Appeal Decision

Appeal Ref: APP/R5510/D/21/3280123
77 St Georges Drive, Ickenham UB10 8HP

- The appeal is made under section 78 of the Town and Country Planning Act 1990 against a refusal to grant planning permission.
 - The appeal is made by Mr Przemek Jasek against the decision of the Council of the London Borough of Hillingdon.
 - The application Ref: 12943/APP/2021/589 dated 13 February 2021, was refused by notice dated 24 May 2021.
 - The development is change of materials (bricks to white render), new non-openable window, installation of roller shutters in each window, installation of PV panels in two locations, replacement of existing fence with new fence.
-

PROPOSED FRONT ELEVATION
1:100

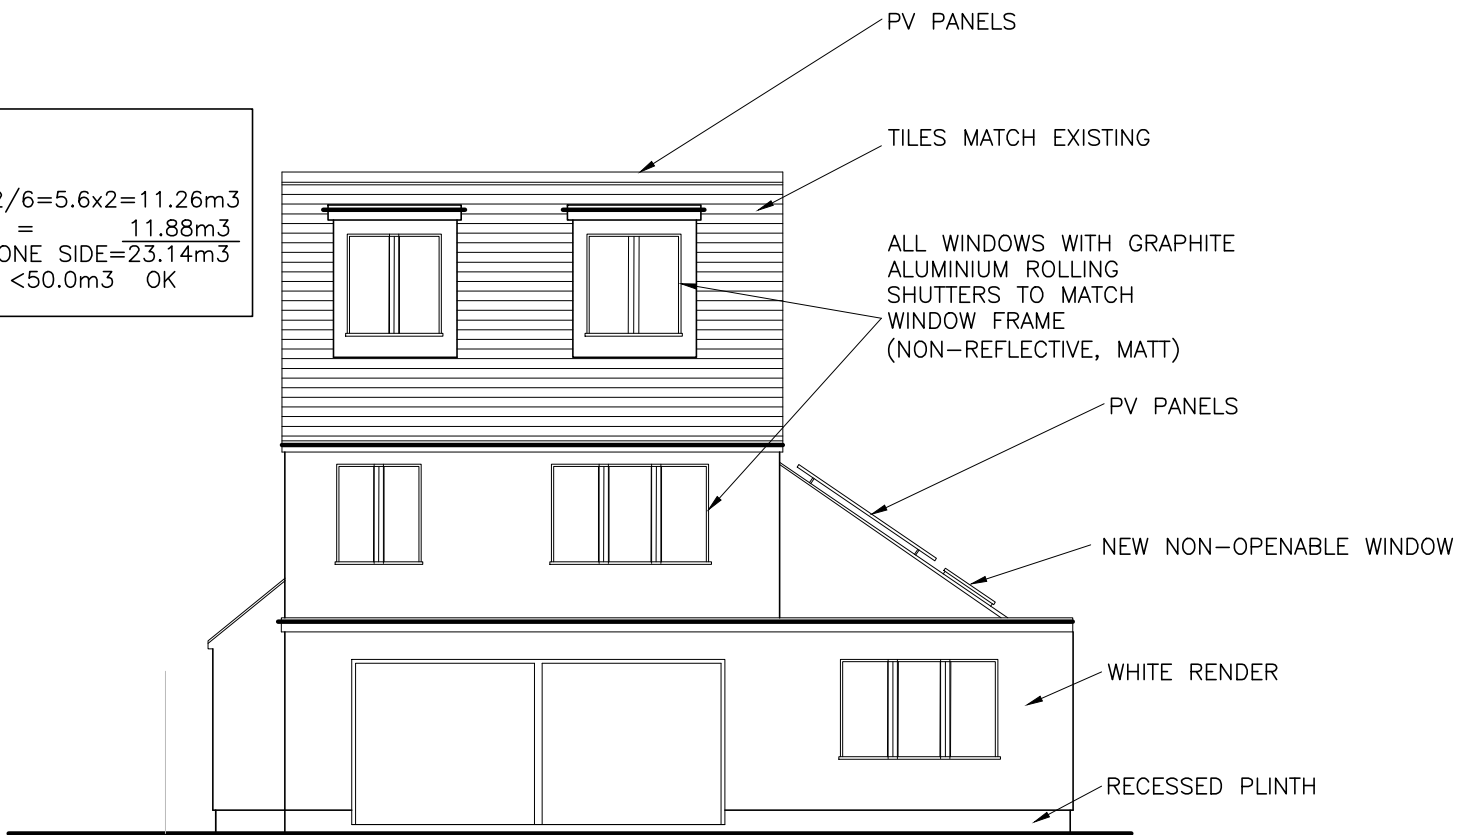
4. The main issue in this appeal is the effect of the proposals, and in particular the change of materials from brick to render and the installation of roller shutters to each window, on the character and appearance of the property and the local area.

- not been drawn, to any other properties with windows with integral external roller shutter blinds.
6. I have been provided with photographs of the existing property before the works were undertaken and the palette of materials appeared to match those found on adjoining properties and generally within the street. Whilst the new finishes to the appeal property have, taken on their own, been completed to a high standard, they significantly and materially alter the existing character and appearance of the property. Given the significant change in appearance with its white render, the property now appears visually obtrusive and unduly prominent in the street scene; it detracts from the coherent character and appearance of the surrounding properties.

7. At the time of my site visit, the shutters were not down on the windows facing the street, but the Appellant has included photographs showing some of these, part down. I have no doubt that whether partly or fully down, the shutters materially and adversely affect the character and appearance of the property, by creating a harsh and incongruous appearance to the property. As a result, the property appears visually discordant and detracts from the street scene.

8. I therefore conclude that the works undertaken, and in particular the change of materials from brick to render and the installation of roller shutters to each window, adversely affect and seriously harm the character and appearance of the existing property and of the local area. This conflicts with Policy BE1 of the Hillingdon Local Plan: Part One Strategic Policies (2012), Policies DMHB11, DMHB12 and DMHD1 of the Local Plan: Part Two – Development Management Policies (2020) and Policies D3 and D6 of the London Plan (2021) and the Framework, in particular Section 12, all of which seek for a high standard of design which respects the local context.
